Re. Planning Application 3/2023/0927 - 2 Sunnyside Ave, Wilpshire

We are writing to object to the retrospective planning permission for the high, closed board fencing at the front of the above property, extending alongside the property on Whalley Road.

drawing title	Proposed Retrospective Site layout Plan and Boundary Treatment Elevation
---------------	---

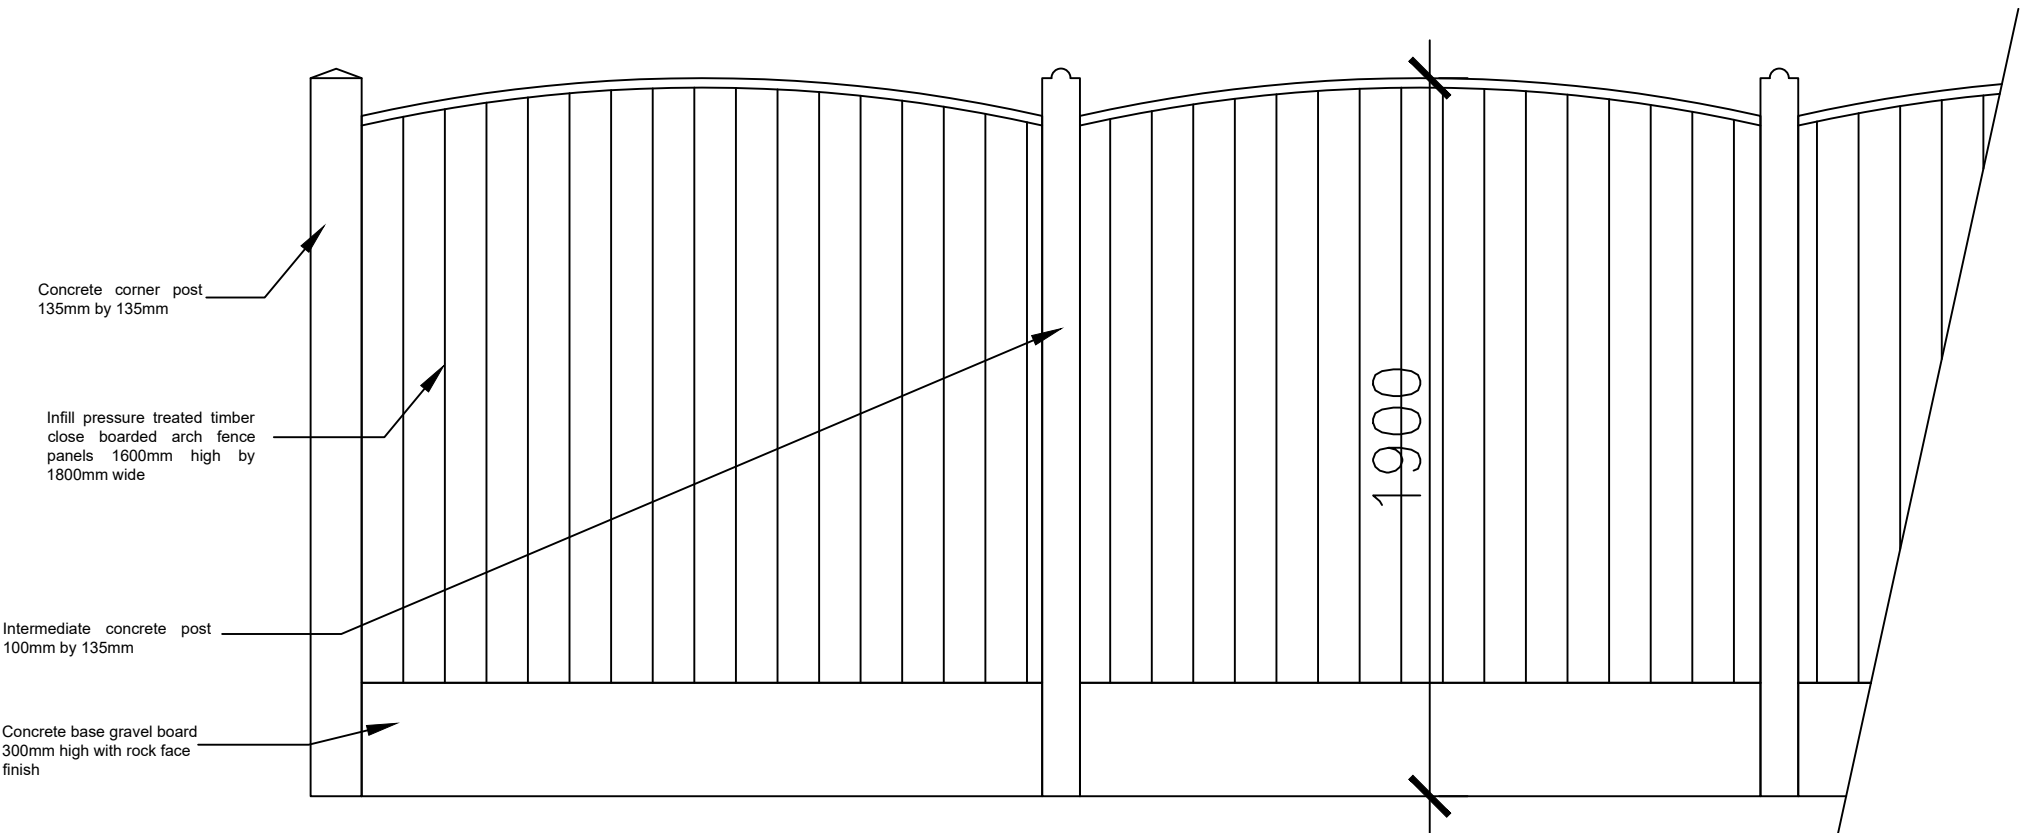
The fence is out of keeping with the area and has an unfavourable effect on the street scene. Most properties consist of low walls, hedges with the odd fence as means of boundary treatment. The area boasts an openness to all the properties and the fence at 2 Sunnyside is overbearing and domineers the property.

The height and close boarded composition of the fence also means cars leaving Sunnyside avenue onto Whalley road have edge out into the cycle lane to gain a clear view of the very busy road before turning onto it.
